RE: Watermark Coal Project (SSD-4975) Publicly Exhibited Environmental Impact Statement

Attachment A. Biodiversity.

Office of Environment and Heritage Response

Figure 3.1. Updated Grassland/Agricultural Area Mapping of the Disturbance Boundary

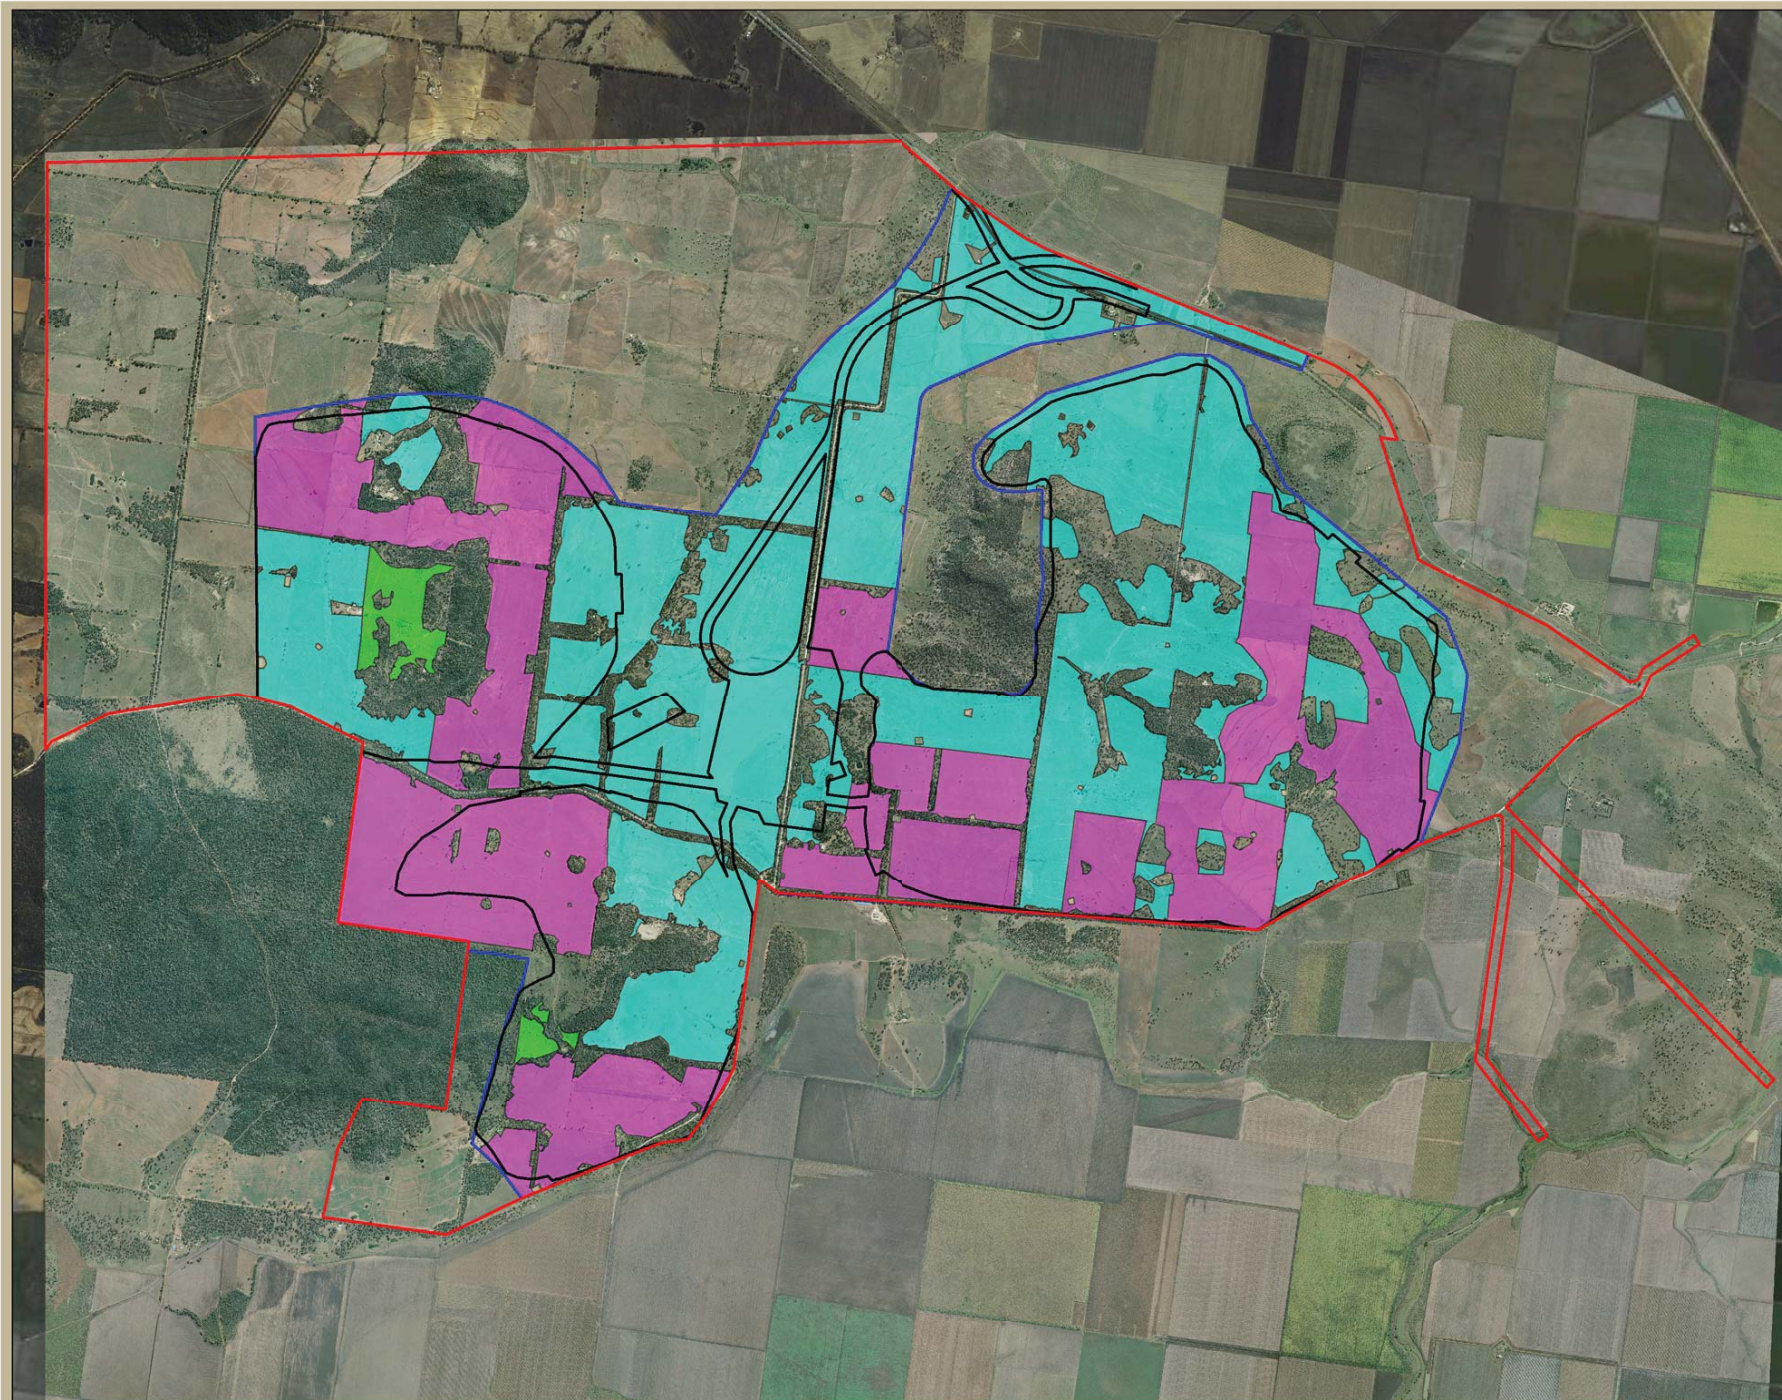
2. Some areas of vegetation currently mapped as “Low diversity grassland, planted and exotic pasture” potentially should be re-mapped as derived native grassland - a component of the Box-Gum Woodland EEC listed under the *Threatened Species Conservation Act 1995*.

In conclusion, the data provided by the proponent does not support their results for the area on the Project site that has been identified as DNG EEC under the TSC Act. According to OEH analysis of the data, much greater areas of the LDG need to be re-evaluated and redefined as DNG EEC under the TSC Act. Furthermore, it is likely that some of the areas in the LDG may fit the definition of the CEEC under the EPBC Act given the high native species richness of some of the plots in the LDG.

The proponent re-evaluate the area of the Derived Native Grassland Box-Gum Woodland C/EEC and Weeping Myall Woodland EEC (if necessary) as defined by the TSC Act and EPBC Act.
